ENG-SF18027-2024R1 - CDs.pdf Markup Summary

Subject:
Page Index: 1
Date: 3/26/2024 10:46:08 AM
Author: Jeff Rice - EPC Engineering Review
Color: 
Layer:
Space:
Page Label: [1] Layout1

N:\118531\DRAWINGS\CONSTRUCTION\03-04-118531-CR-01 AND 05-02.dwg, 3/1/2024, 2:41:43 PM, 1:1

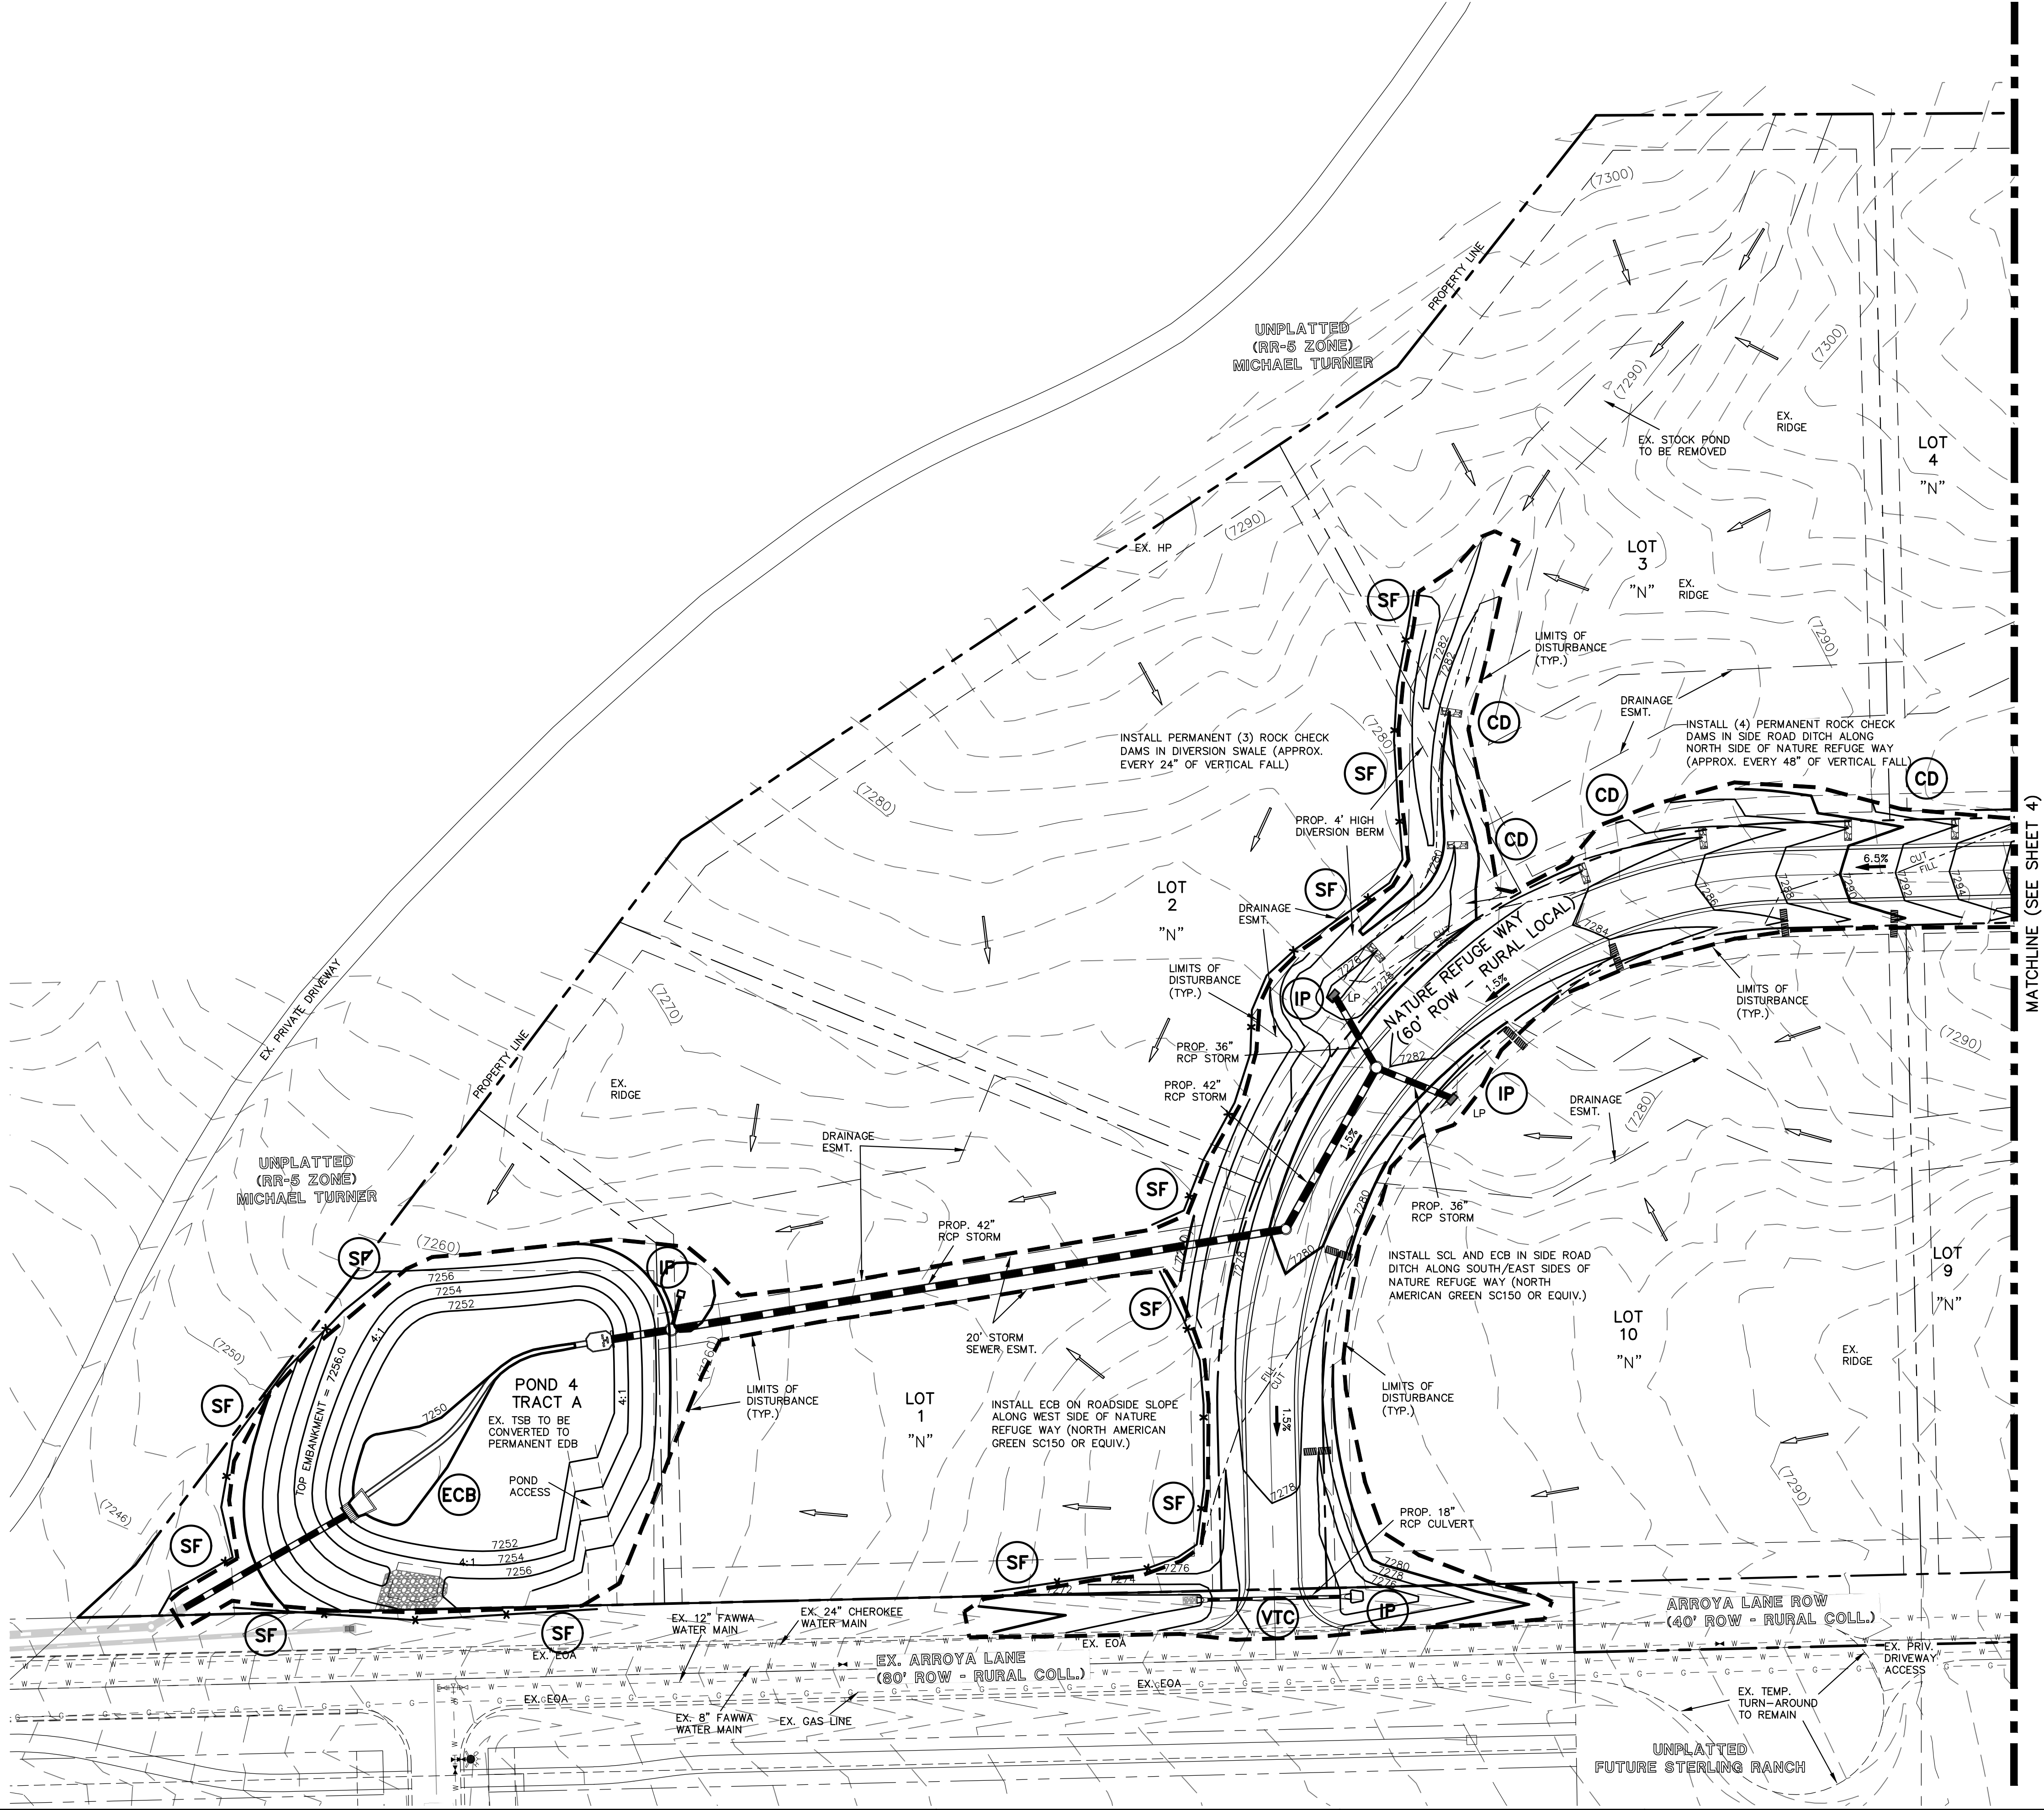
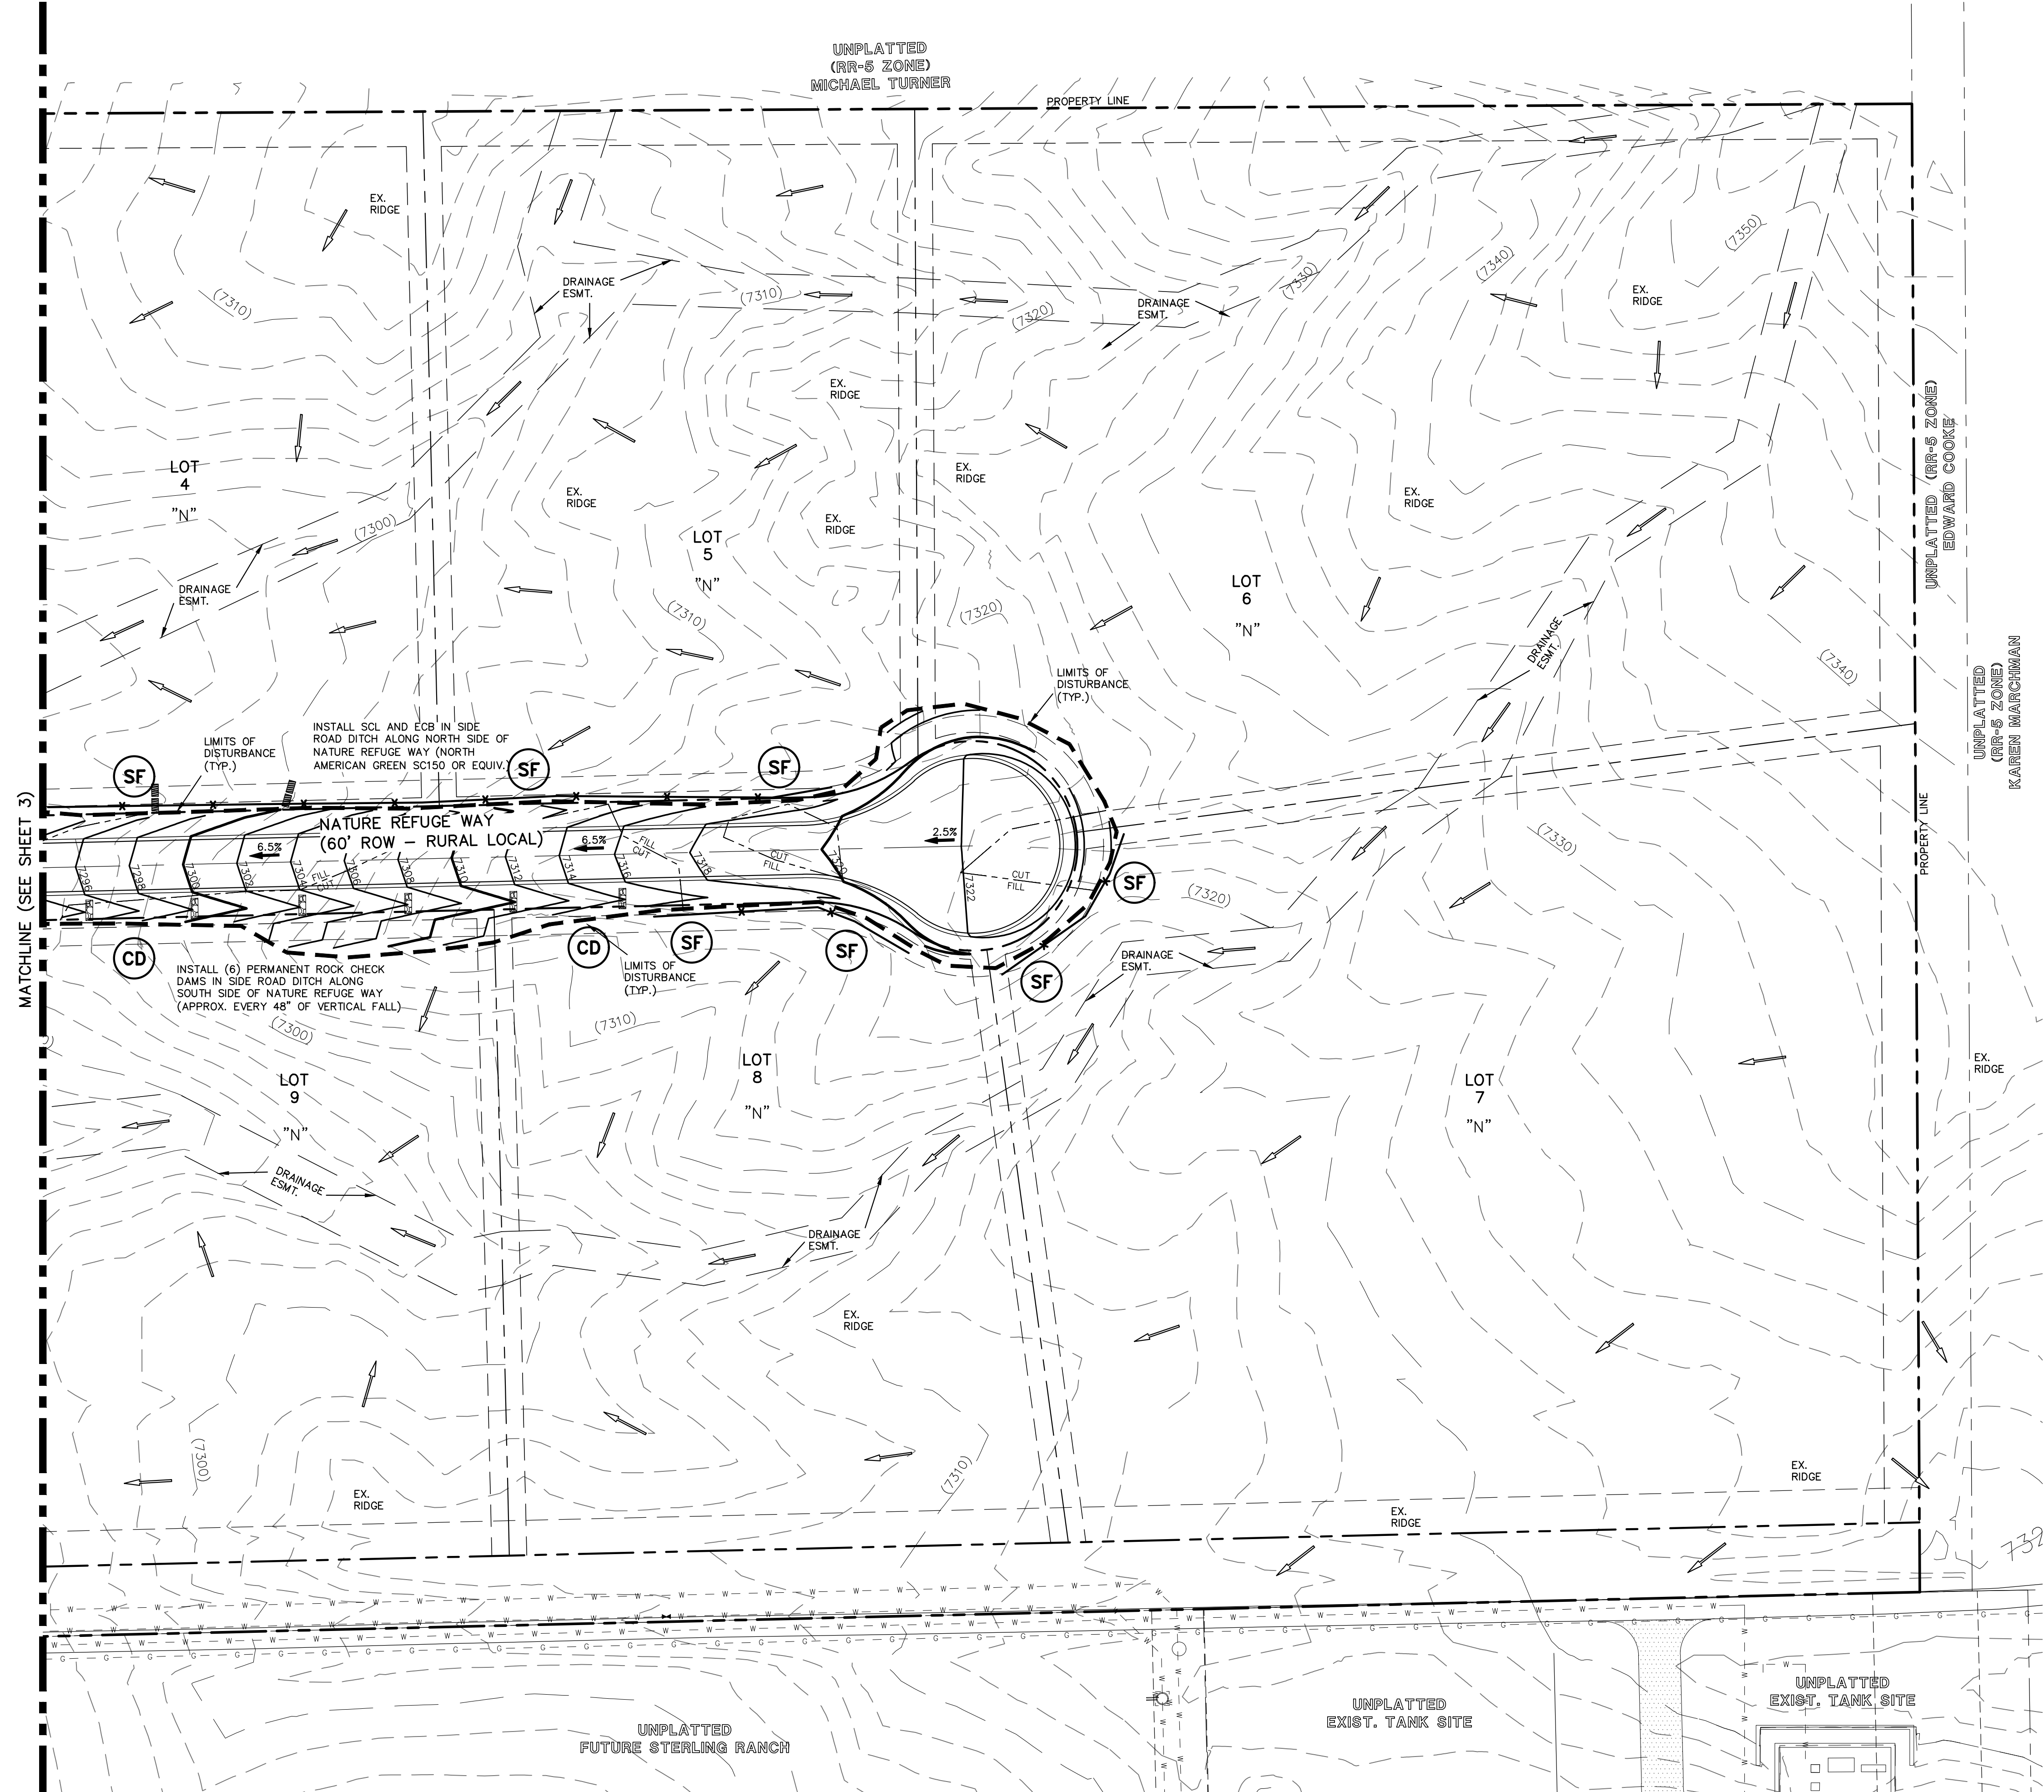
Show areas for stockpiling and staging, clarify if they aren't anticipated, or add a note that those will be determined by the contractor

Show specific limits for ECB - it needs to be clear which areas call for ECB

Show areas for stabilized staging area.

All are listed as through the vertical phase, but clarify which are to be final to be left and which are to be removed with final stabilization. Seeding and mulching are final and not on the phasing list.

Provide ditch detail(s) with minimum dimensions (side slopes, bottom width, depth, etc) for all ditches.

Silt fence should be parallel to contours. Placement as shown could channelize runoff. All silt fence not running parallel to contours shall be installed with J-hooks or adjusted as necessary.

bubble and label as SCL like in the legend (typical comment)

how do this ditch tie into the other ditch? Shift label so it doesn't cut off contours in this section and ensure the two ditches are sufficiently tied together

Are permanent check dams needed? The County does not prefer to accept and maintain permanent check dams because it can make maintenance more difficult.

Label all easement lines
